# Sheringham Shoal and Dudgeon Offshore Wind Farm Extension Projects

The Applicant's Comments on Responses to the  
Examining Authority's Third Written Questions

Revision A  
Deadline 6  
June 2023  
Document Reference: 20,2

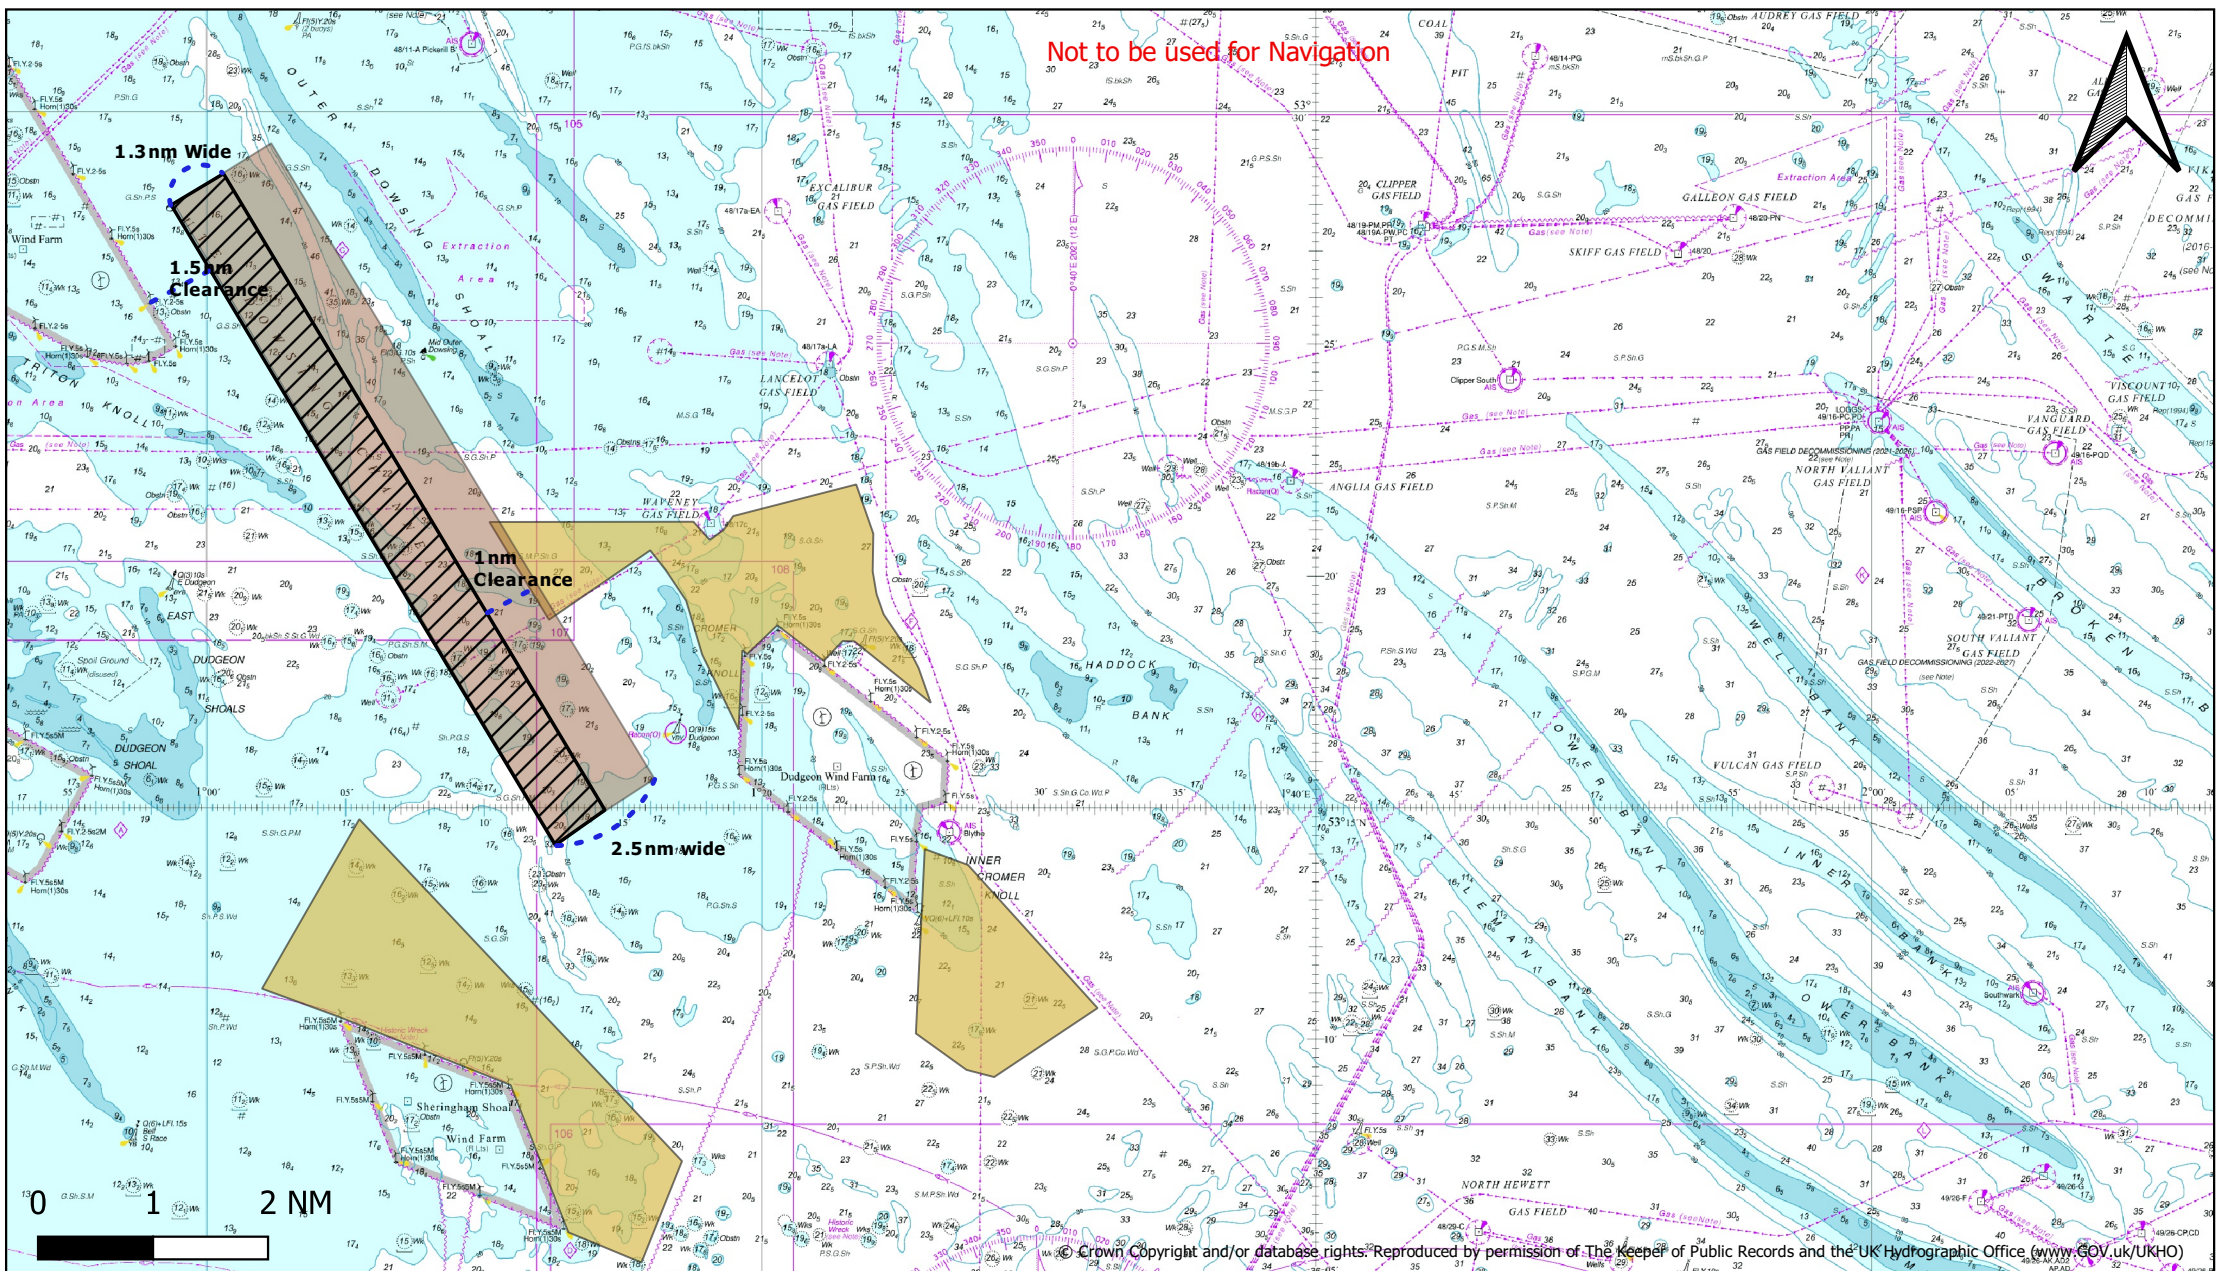
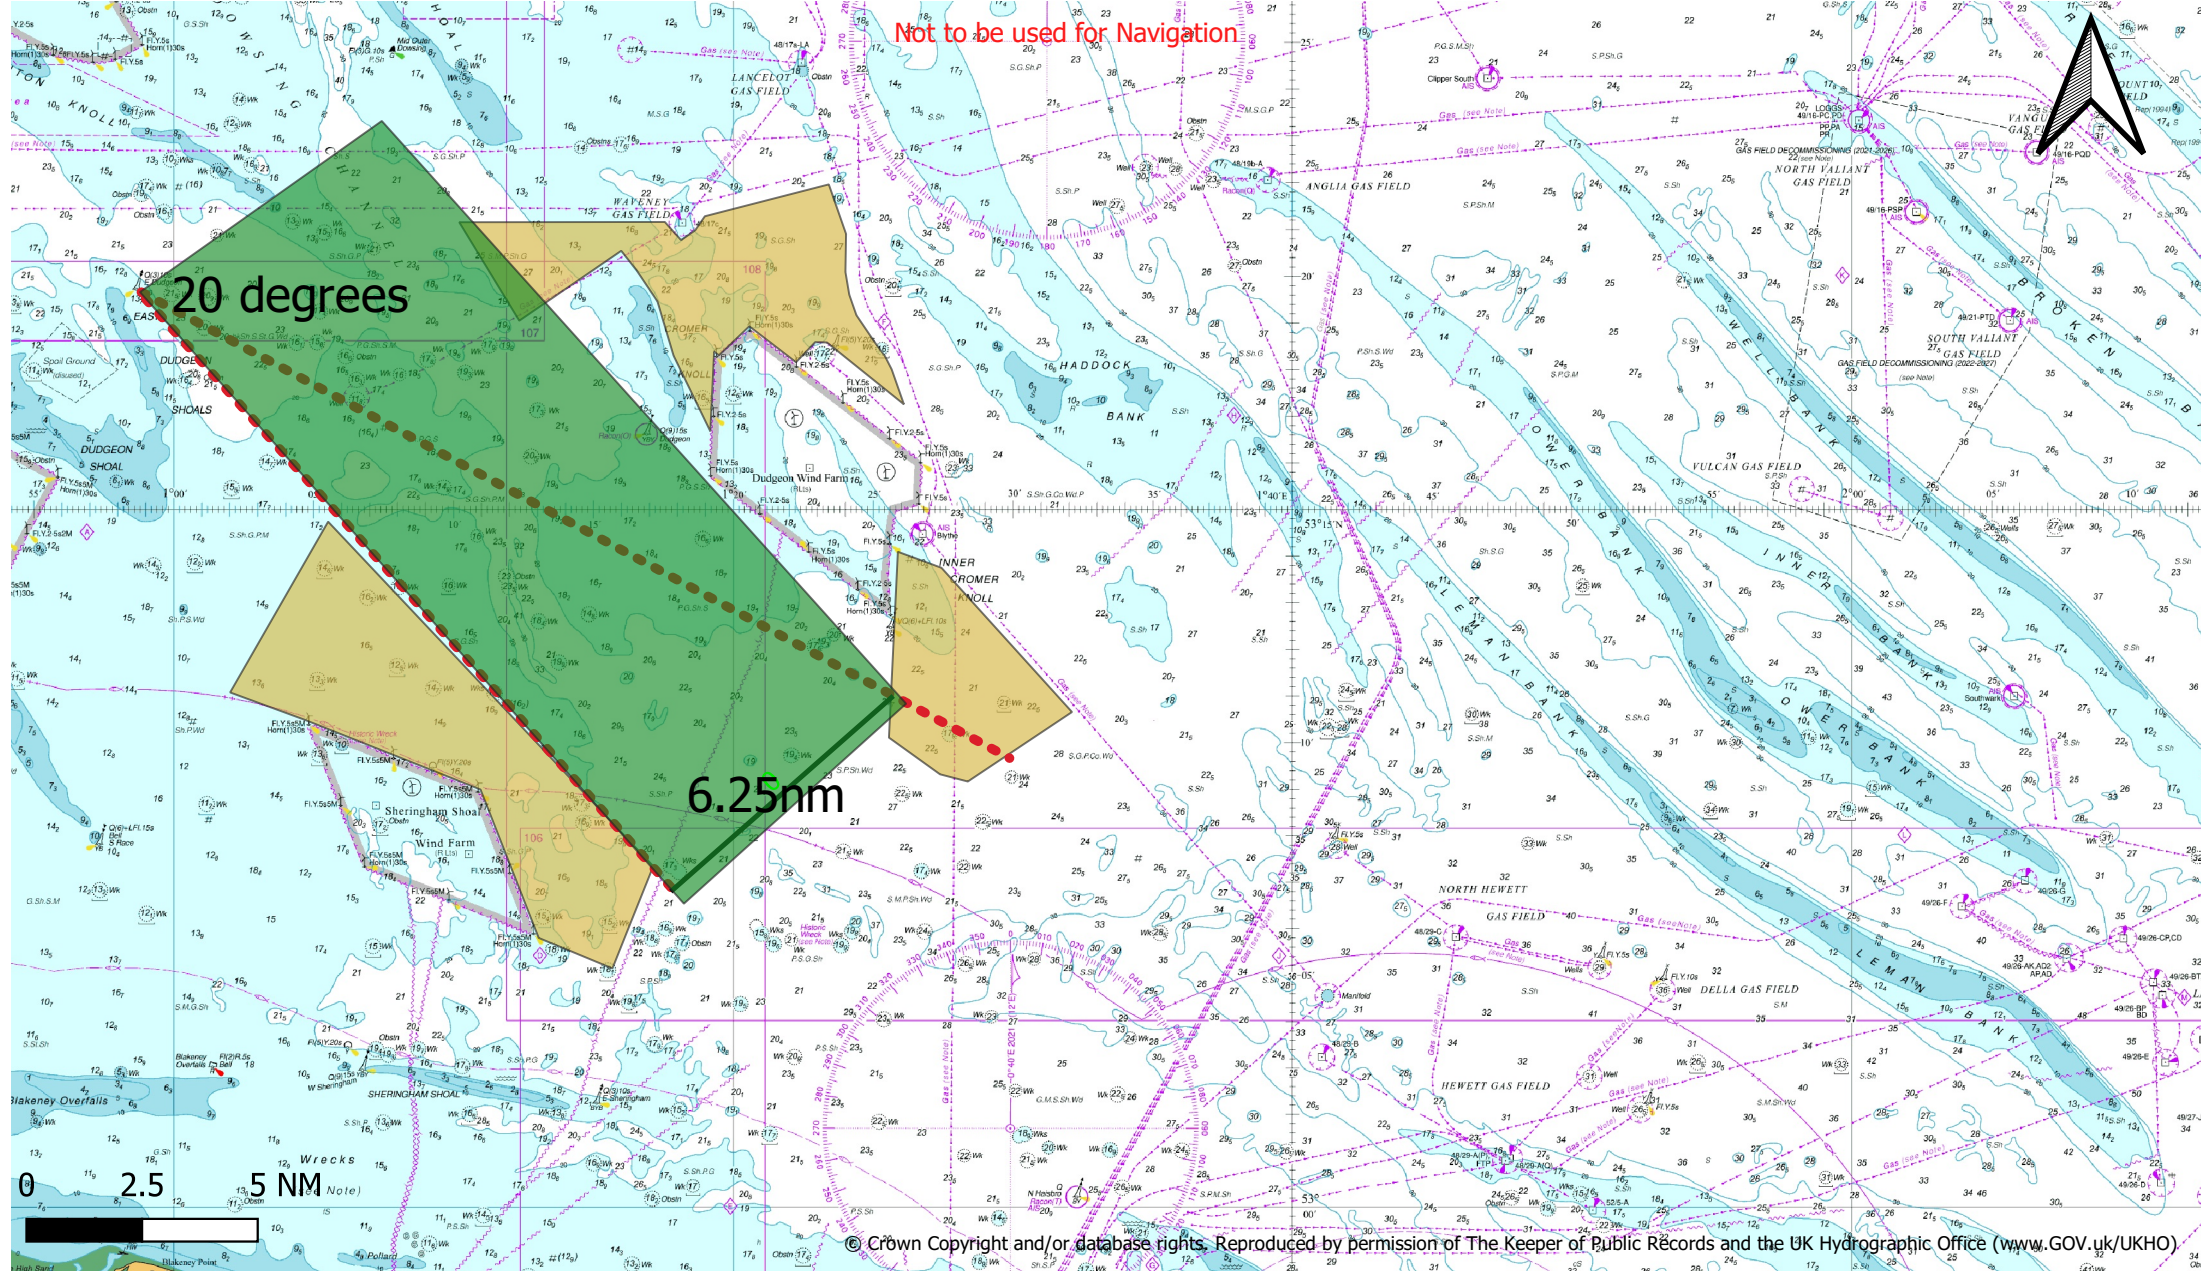
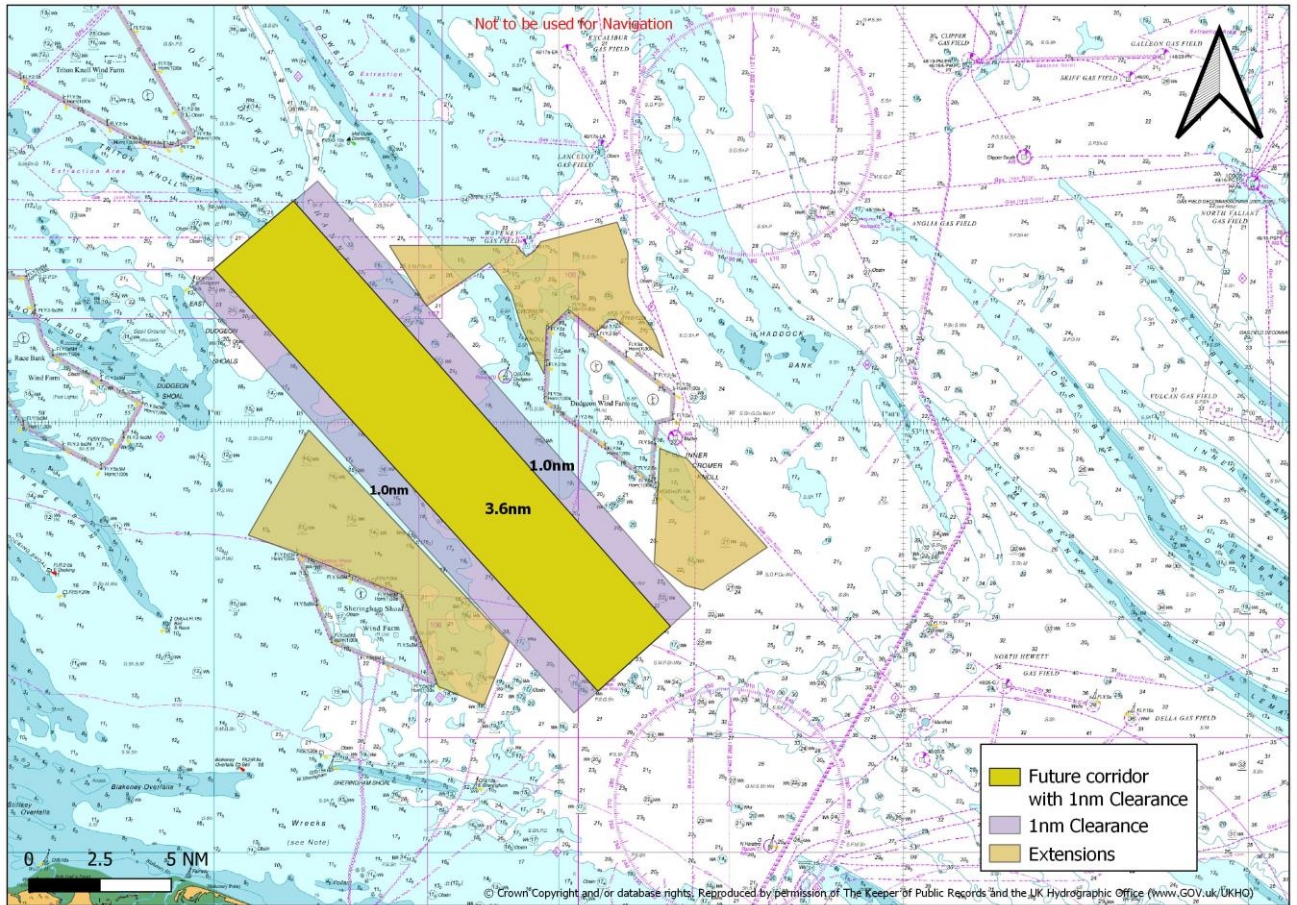
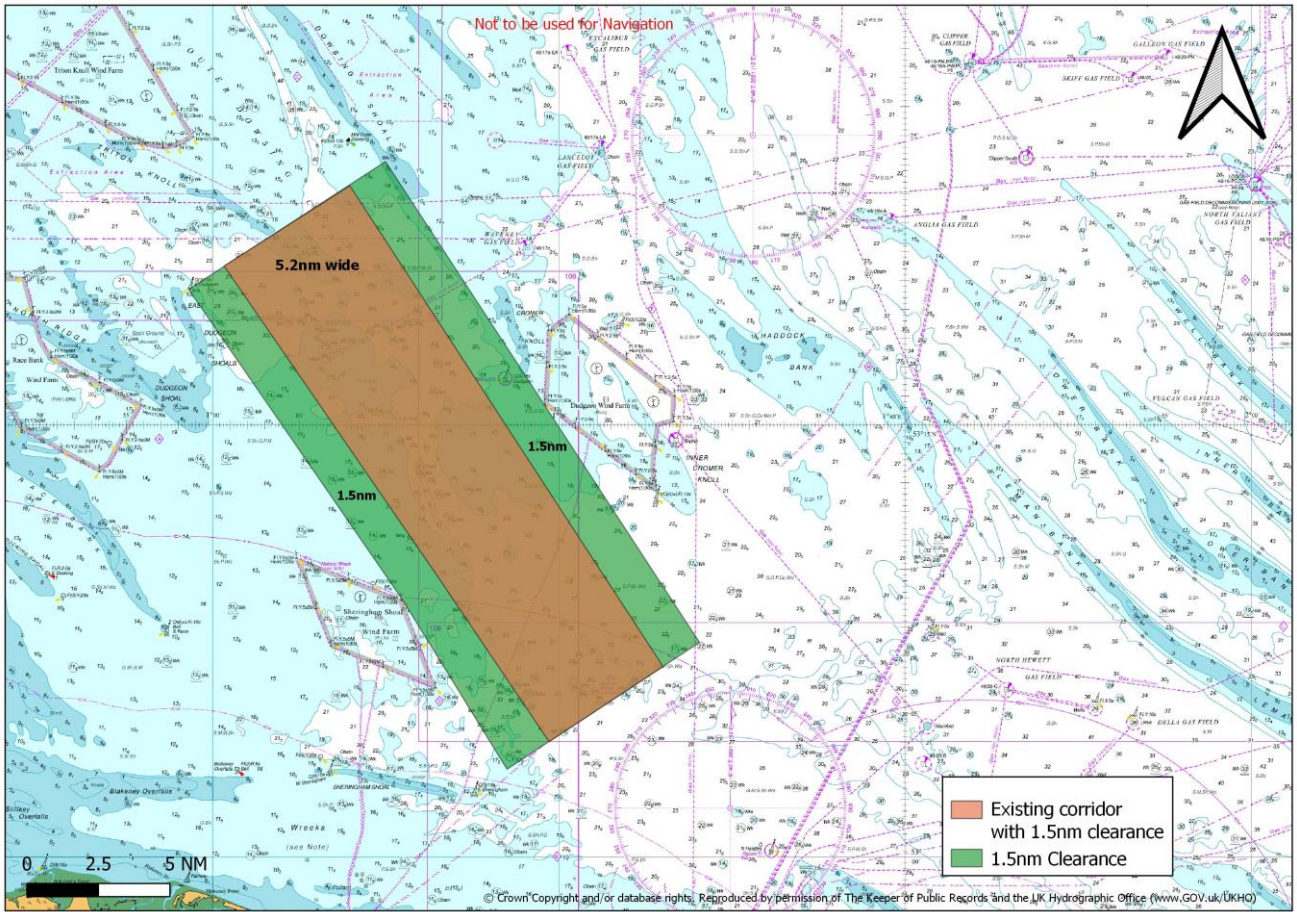
Q3.19.1.2	<p><b>Navigational Risk</b></p> <p>The Applicant, in the Navigational Safety Technical Note [REP3-031] has provided additional modelling of the northwest extent of DEP-North on collision risk for traffic within the Outer Dowsing Channel. This modelling showed a collision risk post windfarm development of 1 in 8.7 years.</p> <p>a) If you disagree with the Applicant's calculations, provide MCA calculations to show what the current collision rate would be compared to if DEP-North was built out as proposed.</p> <p>b) Provide your version of the Applicant's Figure 7.2 of the submitted Navigational Safety Technical Note [REP3- 031], showing anticipated remaining sea</p>	<p>a) The applicant's Navigational Technical Note [REP3-031] assessed the change of collision frequency to increase from 1 in 8.5 years to 1 in 8.7 and it is understood from the meeting with the applicant on 22 May 2023 that it applies to the entire study area, not just the area of concern off DEP North. The MCA does not disagree with the applicant's calculations of baseline collision risk (1 in 8.5 years) as we know the area is already high risk. MCA would expect the localised increase to be higher with the introduction of DEP North. During the meeting with the applicant on 8 June 2023, the applicant confirmed their assessment of the increase in collision risk in the area immediately west of the boundary would be 23% which appeared to confirm our concerns. However, it was noted this was collision risk only. It did not include the associated collision or</p>	<p>The Applicant has noted the response provided by the Maritime and Coastguard Agency in their Deadline 5 submission [REP5-081]. The Applicant will address the points raised in the Maritime and Coastguard Agency's submission at Issue Specific Hearing 7 on 21<sup>st</sup> June 2023 and will provide further details (if required) in writing at Deadline 7.</p> <p>The Applicant notes the Maritime and Coastguard Agency (MCA) reference a localised increase of risk of 23% in the area west of DEP North. The Applicant would like to provide the relevant context behind the number given that the detail has not yet been introduced to the Examining Authority. The Applicant notes that the value when considered in isolation does not provide sufficient detail to understand its meaning,</p>

ID	Question	Maritime and Coastguard Agency Responses	Applicant's Comment
		<p>nor does it allow for the controlling depths as described above.</p> <p>MCA raised concerns at Deadline 1 in our Written Representation that the area already has high collision risk which would only increase when navigating west of the DEP North array. When a safety buffer of 1NM is applied to the DEP North boundary, our assessment is that vessels will be constricted into a channel 1.3NM wide. This is a reduction of 58% from the current navigable sea room. It should be noted that this only applies to the operational phase. During the construction phase construction buoys will be deployed and the available sea room will be less than 1.3NM. An estimation of the sea room in this instance will not be possible until the positions of the construction buoys are known.</p> <p>At Deadline 3 we explained that the frequency of encounter (head on and converging traffic) will increase, and the constriction of sea room will affect vessels' ability to take early and substantial action in accordance with the International Regulations for Preventing Collisions at Sea, 1972, as amended (known as the Collision Regulations or COLREG). The proposals will likely result in a departure from COLREG or alteration of course either towards the</p>	 <p><i>Figure 2 – Localised Area of Interest relative to Study Area</i></p> <p>The localised results showed collision return periods as follows:</p> <ul style="list-style-type: none"> <li>• 140 years within the original NRA [APP-198] modelling i.e., if DEP North is fully built out.</li> <li>• 172 years within the sensitivity analysis [REP3-031] i.e., if DEP North is not fully built out.</li> </ul> <p>The 23% value the MCA reference is then the difference between the 172 year return period and the 140 year return period. Assuming an operational lifespan of 40 years, the modelling indicates a collision incident would not be expected during the project lifespan in this localised area in either scenario. This makes the DEP North area lower risk than the wider area on an absolute basis.</p>

ID	Question	Maritime and Coastguard Agency Responses	Applicant's Comment
		<p>windfarm red line boundary thus increasing the risk of allision, or towards the shallows thus increasing the risk of grounding. This is particularly relevant for southbound traffic merging with the traffic transiting south of Triton Knoll windfarm, avoiding northbound traffic, avoiding active fishing vessels that may have restricted manoeuvrability and construction/maintenance vessels.</p> <p>c) The MCA is not resourced to provide statistical modelling figures, the necessity of which would apply in equal measure to all UK offshore renewable energy installation projects. Instead, our qualitative assessment is based on the professional and expert judgement of MCA mariners using their knowledge and understanding of seamanship and safe seafaring practices. The concerns are regarding the interpretation of the significance of the risk at current traffic levels and the statistical modelling results do not correlate with our interpretation of future traffic behaviour and good seamanship practices for collision and allision avoidance. The potential increases of traffic volume by 10% and 20% would</p>	<p>Whilst it is noted that the MCA also state that they would expect 'the localised increase to be higher with the introduction of DEP North' it is important to understand probabilities when considering increase in risk. The Applicant demonstrated in the meeting on the 8<sup>th</sup> June 2023 the frequency of two or more commercial vessels being within the same half an hour period within a localised area of the Outer Dowsing channel was less than 3.5% during 2019 (based on the 12 months of AIS data)<sup>3</sup>. This indicates the probability in a future case scenario of two or more commercial vessels encountering each other is low, when then considering historical incident data the probability of one of those encounters resulting in a collision (noting the application of mitigations) is very low. Therefore, loss of sea room does not directly result in a high collision frequency if the probability of an encounter is low which is indicated by the return period of 1 every 140 years.</p>

ID	Question	Maritime and Coastguard Agency Responses	Applicant's Comment
		<p>naturally increase the risks, and our concerns, even further.</p> <p>d) The MCA considers the increase in collision risk in the DEP North area to be unacceptable. This takes into consideration the local effect of the DEP North extension and the already high collision risk associated with the naturally confined waters of this part of the North Sea.</p>	
Q3.19.1.4	<p><b>Mitigation against risk</b></p> <p>If the route past DEP-North would pose an unacceptable risk post windfarm development then is there other mitigation or measures available to address this, other than the omission of turbines close to this route to keep the sea room as existing? For example, could this route be avoided or recommended against for vessels traversing this area, using an alternative route instead?</p>	<p>MCA has considered IMO-adopted ship routing and it is not considered appropriate in this instance due to the narrow sea room available. The area is too confined for a Traffic Separation Scheme (TSS) and a Precautionary Area would do very little to address the issue of reduced sea room at the northern part of the extension. Head on traffic may be mitigated with a recommended route or a two-way route but it would effectively reduce the widths of both northbound and southbound routes where there would be insufficient sea room to take avoiding action in other close quarter situations such as crossing and overtaking. A cautionary note on the navigational chart has also been considered but it would only alert the mariners' attention, not reduce the risk or increase sea room. The only acceptable mitigation measure available is to reduce the red line boundary to ensure the available sea room is maintained.</p>	<p>The Applicant has noted the response provided by the Maritime and Coastguard Agency in their Deadline 5 submission [REP5-081]. The Applicant will address the points raised in the Maritime and Coastguard Agency's submission at Issue Specific Hearing 7 on 21<sup>st</sup> June 2023 and will provide further details (if required) in writing at Deadline 7.</p>

Q3.19.1.8	<p><b>Sea room between SEP and DEP</b> Please confirm that it is only the loss of sea room to the west of the northern section of the DEP array that the MCA is concerned with, with no objections to the width of sea room that would remain between SEP and DEP?</p>	<p>MCA's concern is the loss of sea room to the west of the northern section of the DEP array that will constrict the two-way traffic into a channel with less than half of the current sea space. MCA is content with the width of sea room between SEP and DEP to the south.</p>	<p>The Applicant has noted the response provided by the Maritime and Coastguard Agency in their Deadline 5 submission [REP5-081]. The Applicant will address the points raised in the Maritime and Coastguard Agency's submission at Issue Specific Hearing 7 on 21<sup>st</sup> June 2023 and will provide further details (if required) in writing at Deadline 7.</p>

ID	Question	Maritime and Coastguard Agency Responses	Applicant's Comment
Q3.19.1.8	<p><b>Safety Zone Widths</b></p> <p>Does the Navigational Safety Technical Note [REP3-031, Figure 6.2] demonstrate that vessels are content with passing approximately 1 nautical mile from windfarms?</p>	<p>It is important to note the difference between a safety buffer distance and clearance, although the terms are used interchangeably. A safety buffer will provide the space that vessels may use in case of a collision avoidance manoeuvre, whereas clearance is the minimum distance vessels might intend to keep at all times from a wind farm boundary, in accordance with an operator's Safety Management System. The safety of the vessel and any parameters associated with passage planning will, ultimately, lie with the Master of the vessel. The applicant's Navigational Technical Note (REP3-031), Figure 6.2 shows that a majority of vessels pass at 1NM or further. The presence of other restrictions in the area such as shallow banks and wrecks (which reduce the safe navigable depth) are also considered, along with weather, sea conditions, vessel type and vessel manoeuvrability. These factors will be under consideration when passage planning and the perceived safe passing distances may be greater than 1NM. We cannot agree that 'vessels are content with passing approximately 1NM from windfarms' as shipping operators and vessel Masters may have requirements for wider passing distances (i.e on a location and vessel specific basis). However, we have used a 1NM clearance as a minimum which, from the data presented in the NRA (APP-198) and Navigational Technical Note (REP3-031), is consistent and reasonable.</p>	<p>The Applicant has noted the response provided by the Maritime and Coastguard Agency in their Deadline 5 submission [REP5-081]. The Applicant will address the points raised in the Maritime and Coastguard Agency's submission at Issue Specific Hearing 7 on 21<sup>st</sup> June 2023 and will provide further details (if required) in writing at Deadline 7.</p>
